From: Lorimer, Elliott <Elliott.Lorimer@lancashire.gov.uk>
Sent: 16 August 2019 15:09
To: planning
Subject: FAO Adrian Dowd re: further Consultation on planning application 3/2019/0588 Holden Clough Nursery, Bolton by Bowland Road, Bolton by Bowland BB7 4PF

The application is for the change of use of agricultural land to parking and landscaping, two poly tunnels and a stone service area.

Holden Clough Nursery -
Proposed Overflow Car
Park & Growing Area
Scale: 1:500 @ A3

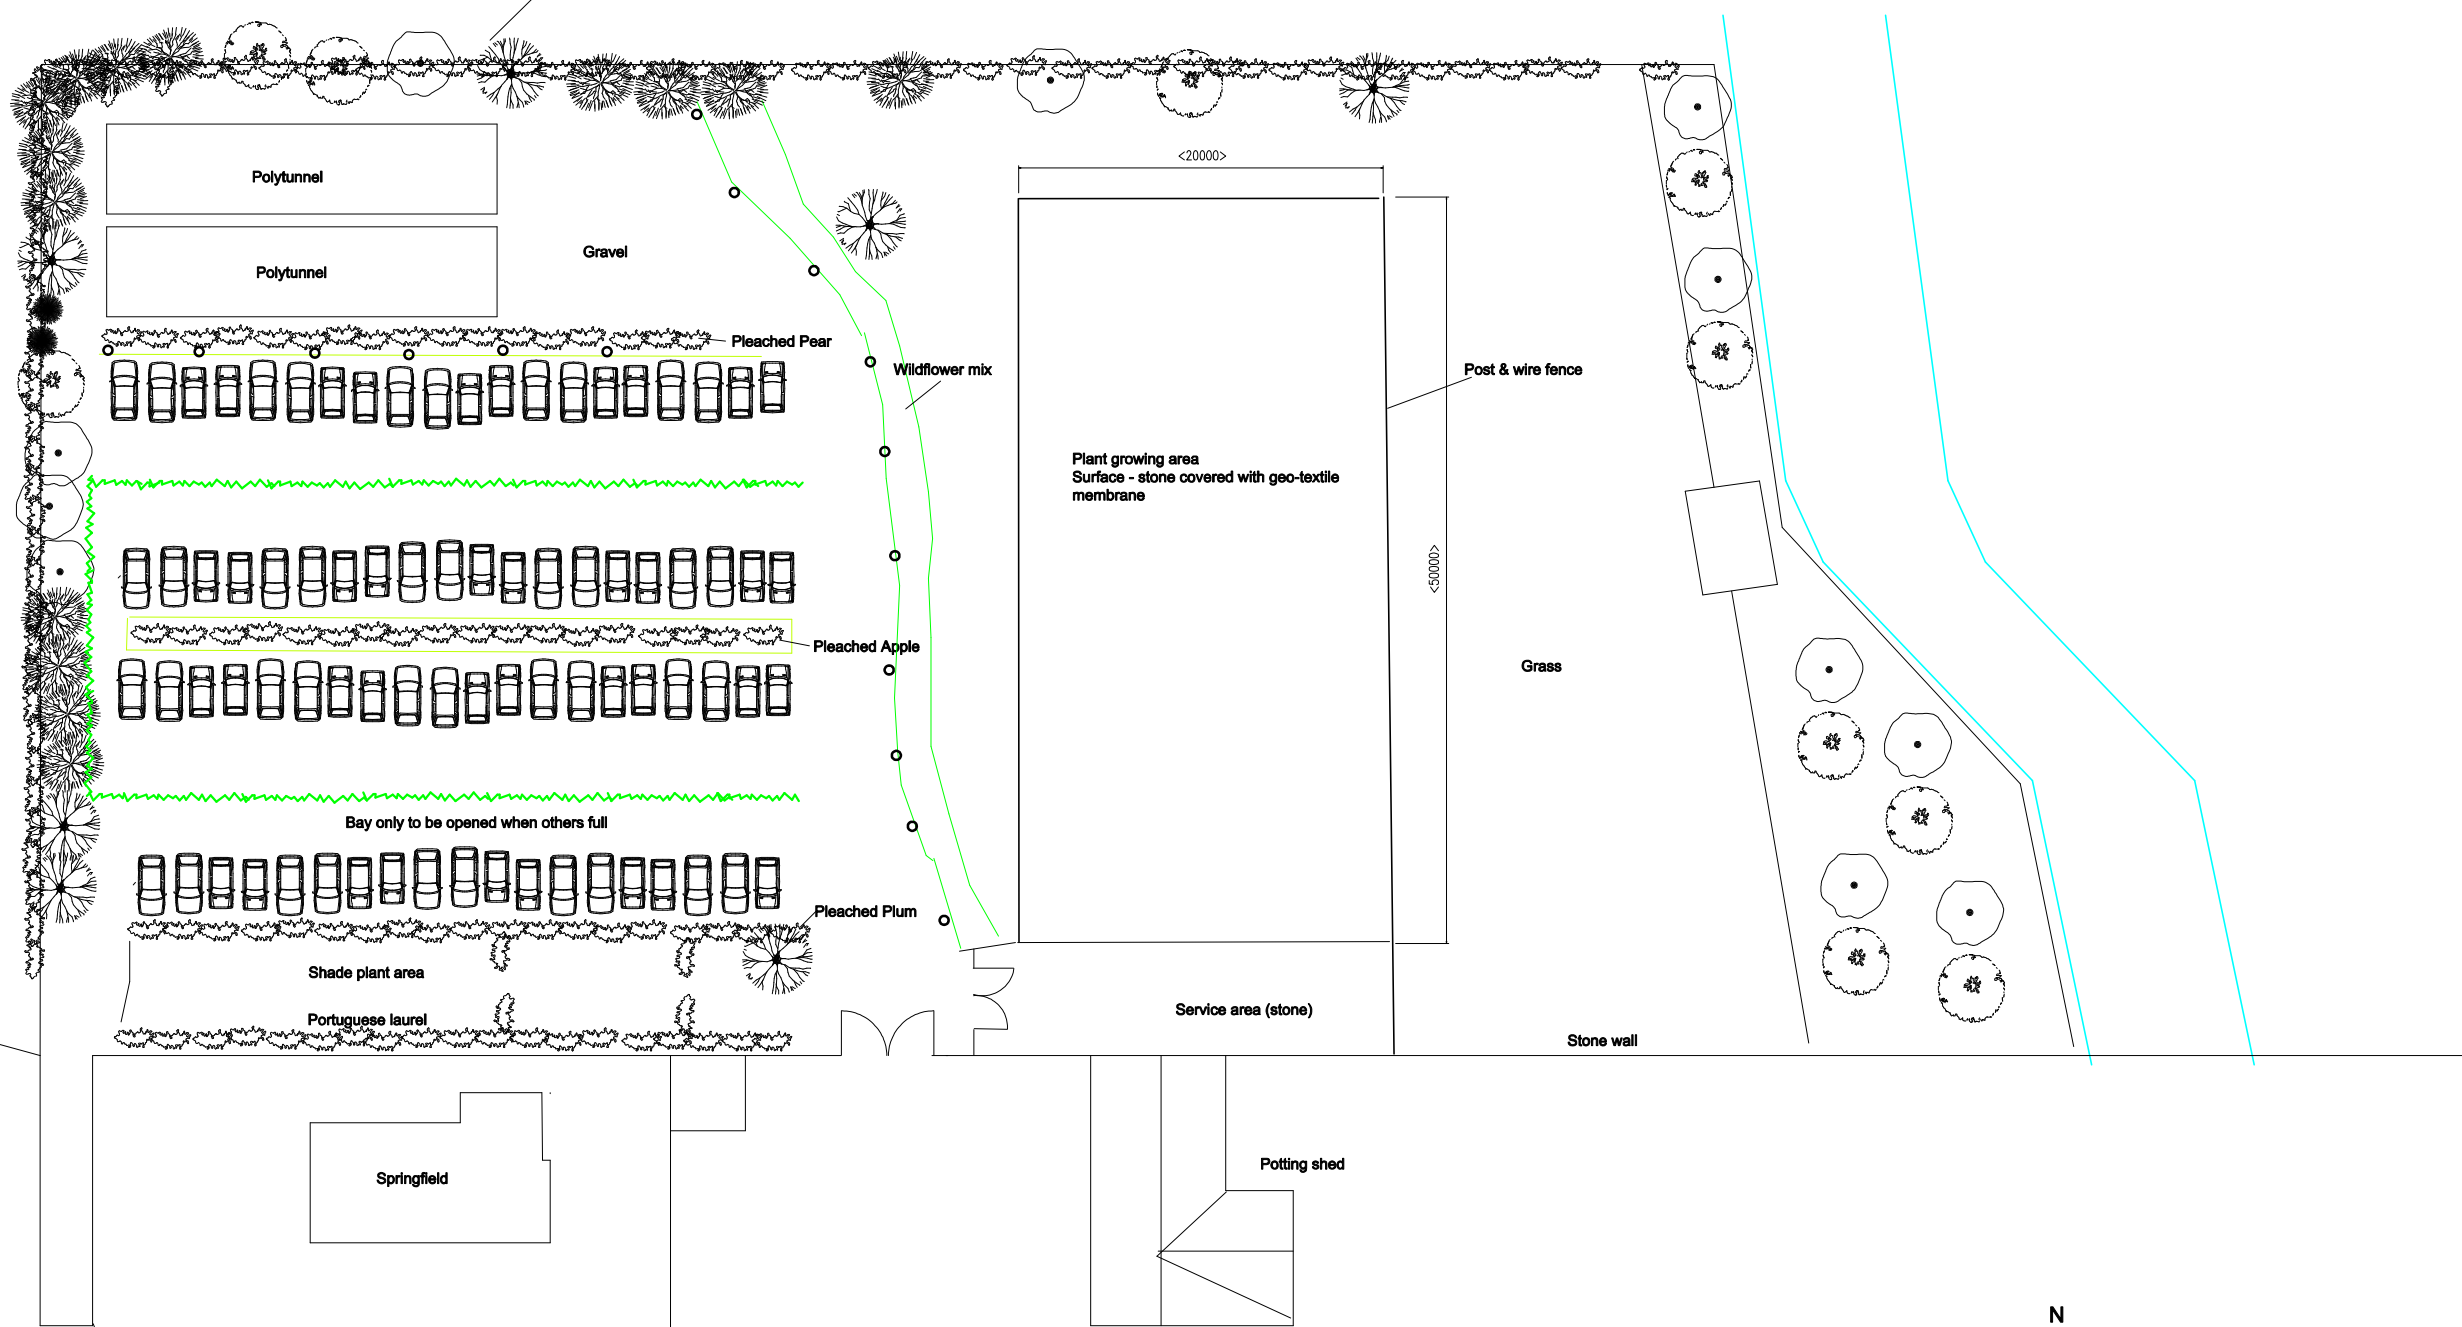
The proposal of the enhanced tree-planting on the western boundary of the site is to be welcomed. However, I do still feel that a similar approach should be replicated along the northern boundary of the site, in particular along the line of the hedgerow adjacent to the proposed polytunnels. The addition of some hedgerow trees along this boundary would help to lessen any visual effects created by the polytunnels above the height of any hedgerow.
